**CITY OF ALBUQUERQUE
PLANNING DEPARTMENT
September 29, 2004
DRB Comments**

PROJECT # 1003293

RE: Tract F-7-A, Atrisco Business Park, Unit 3/SPBP

TRACT F-7-A, ATRISCO BUSINESS PARK
 3DRBP SITE PLAN

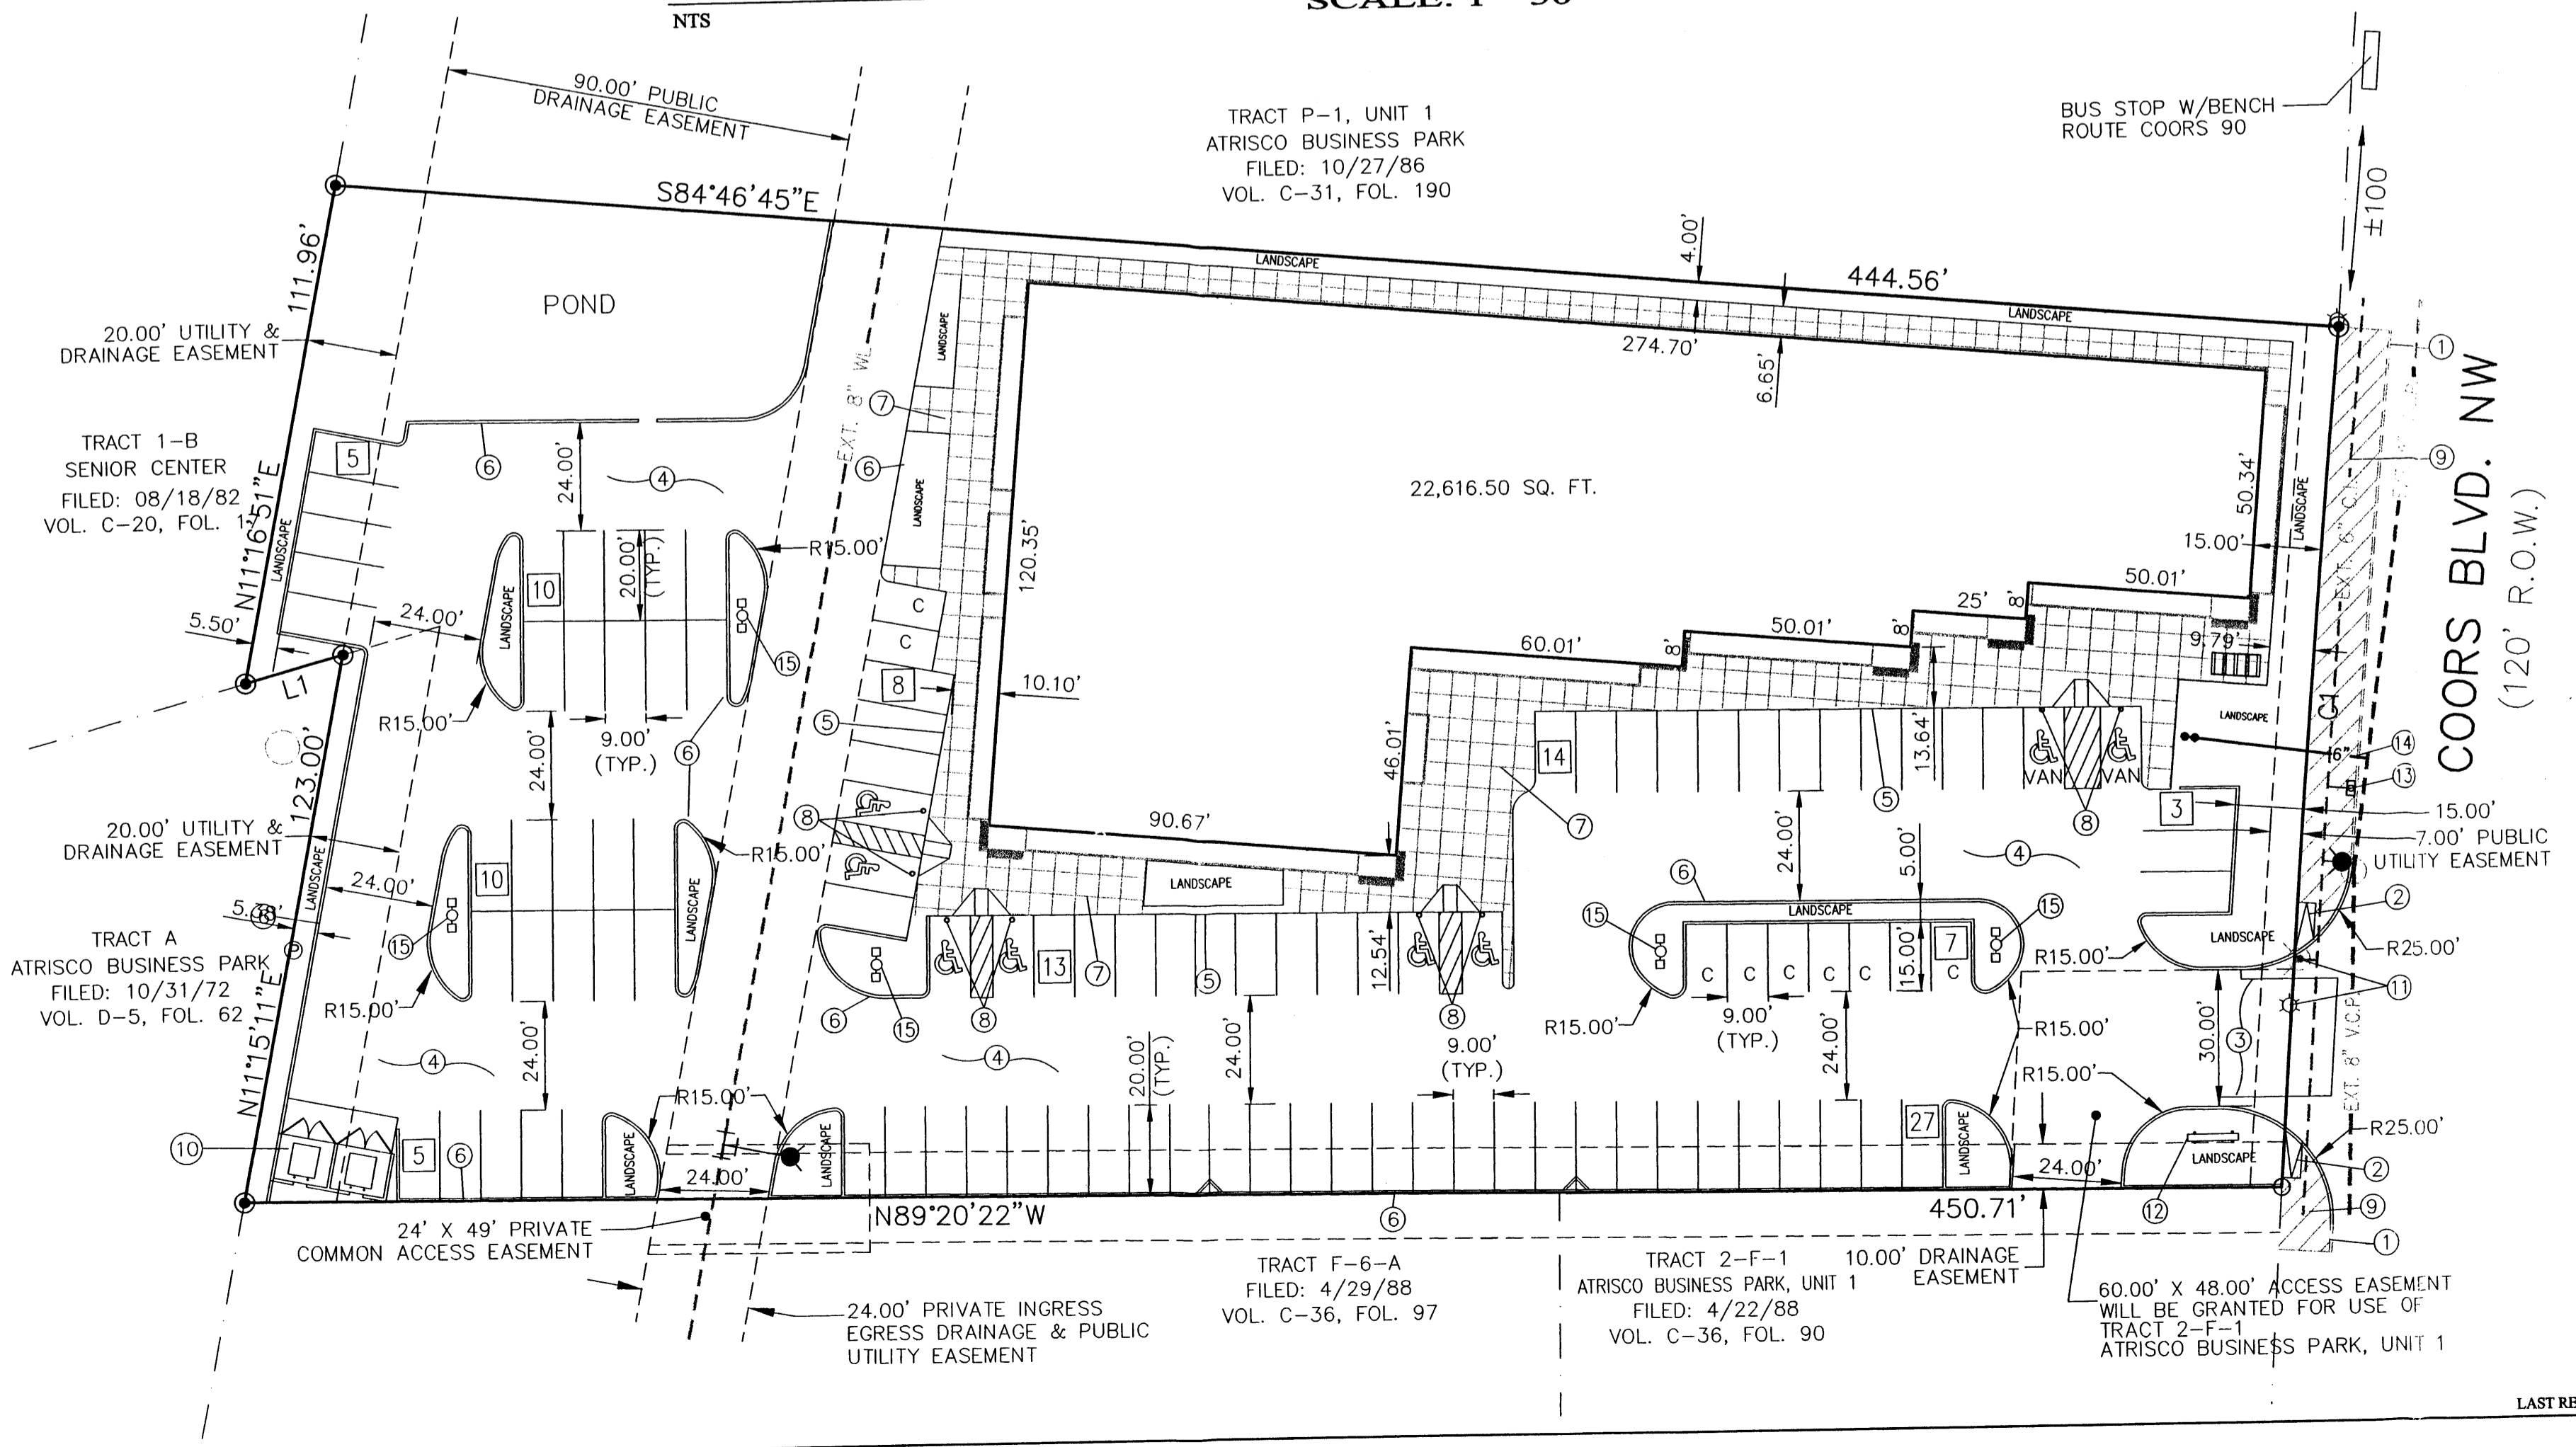
1. The site plan sheet should be titled "Site Development Plan for Building Permit". The word "signoff" in the signature block title should be removed as this plan was not reviewed by EPC.

2. Walls Fences & Screening is checked on the checklist. Where?

3. The Coors Corridor Plan requires a 15 foot landscape setback for Coors. The current landscaped area is about 4' on the east side of the building.

4. Site Lighting. The checklist requires height, fixture type and location indicated on the Site Plan for Building Permit (SPBP). See also Page 98 of the Coors Corridor Plan, Policy 9, Site Lighting Design Regulation #2.

5. Bus Facilities. Again, this item is checked, indicating some type of bus facility is on the SPBP. Where?

8. Signs should follow the Coors Corridor Plan (CCP) requirements. The required details must be on the SPBP to determine compliance. The SPBP checklist requires dimensions & square footage as well as materials & colors for each sign, including building mounted signs and directory signs. The locations should also be indicated on the SPBP site plan sheet.

9. The CCP requires landscaping on a minimum of 20% of the parking area. Please provide calculations to show this is the case. Also the APBMP requires that no parking space be placed more than 100 feet from a tree. The south end of the parking area does not comply.

10. Note "H" on the Site Plan sheet. Move to Elevations Sheet. The other notes are not needed. They should be incorporated into the overall design of the site & reflected on the SPBP as applicable.

**TRACT F-7-A, ATRISCO BUSINESS PARK
 LANDSCAPING PLAN**

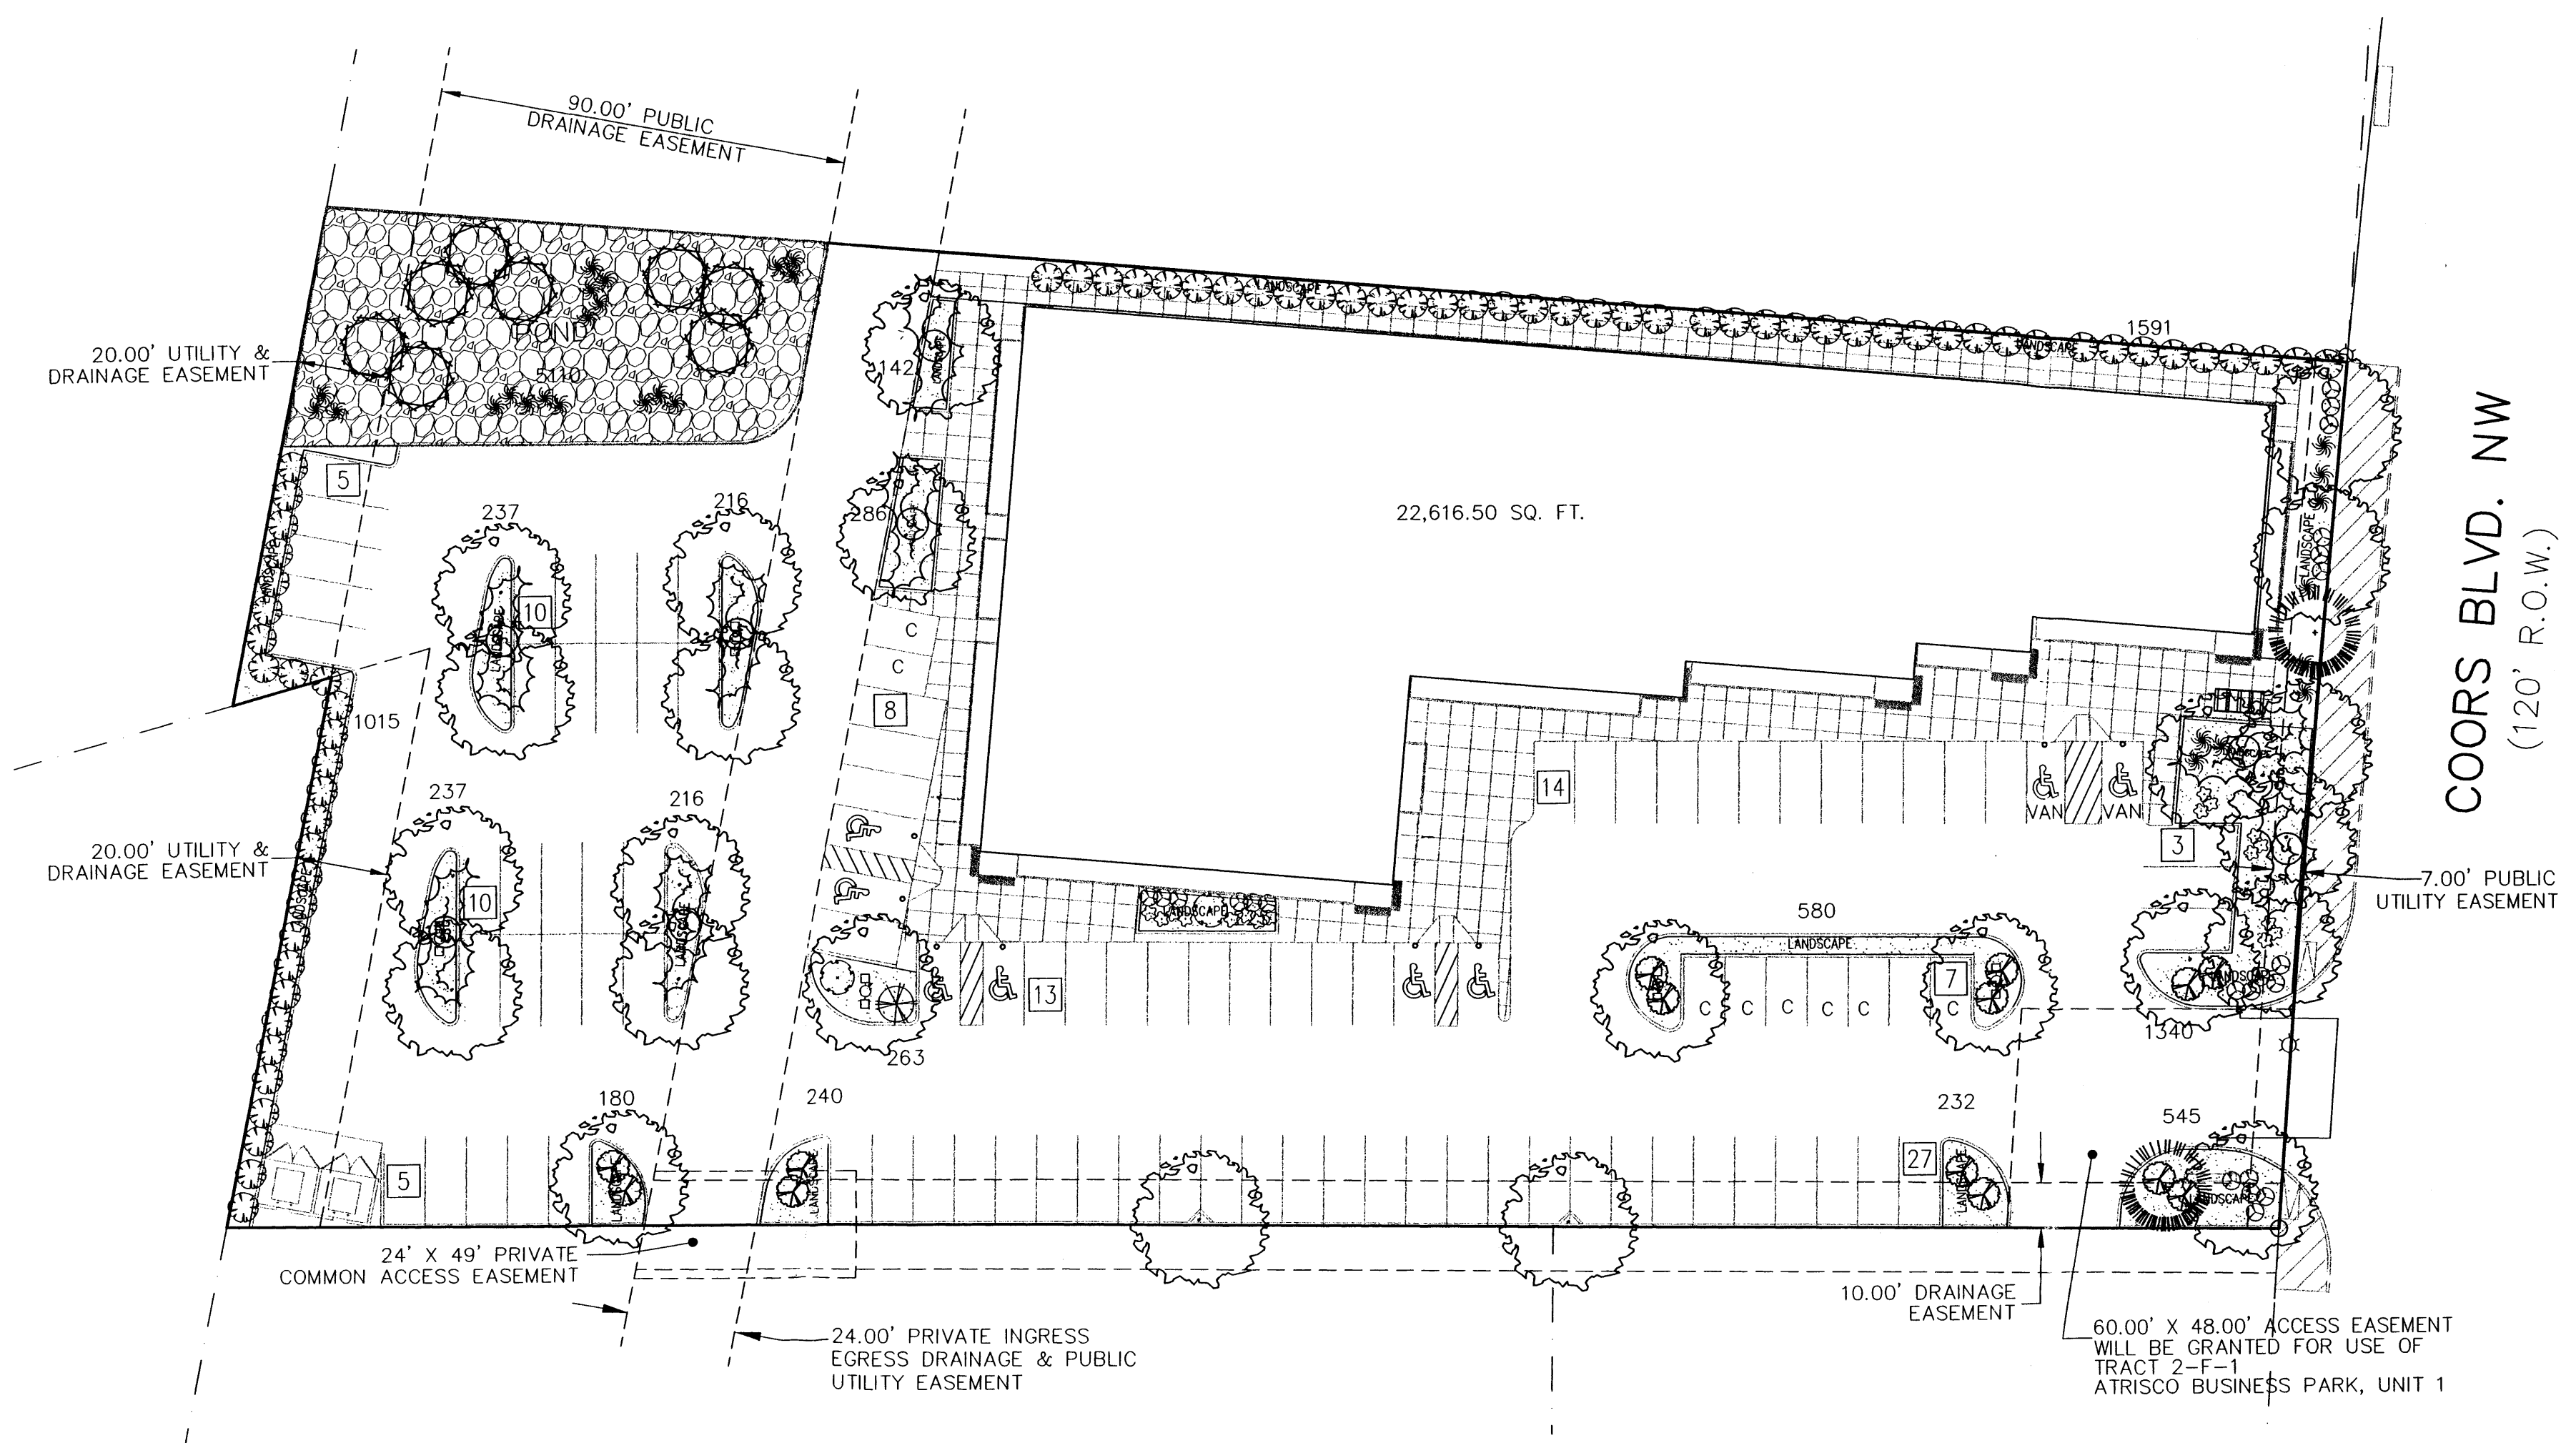
7. Landscape Plan. Given the current water shortage & conservation emphasis in Albuquerque now, the number of high water usage trees should be reduced to 8 maximum.

The existing and proposed easements are not shown on the Landscape Plan as required by the checklist.
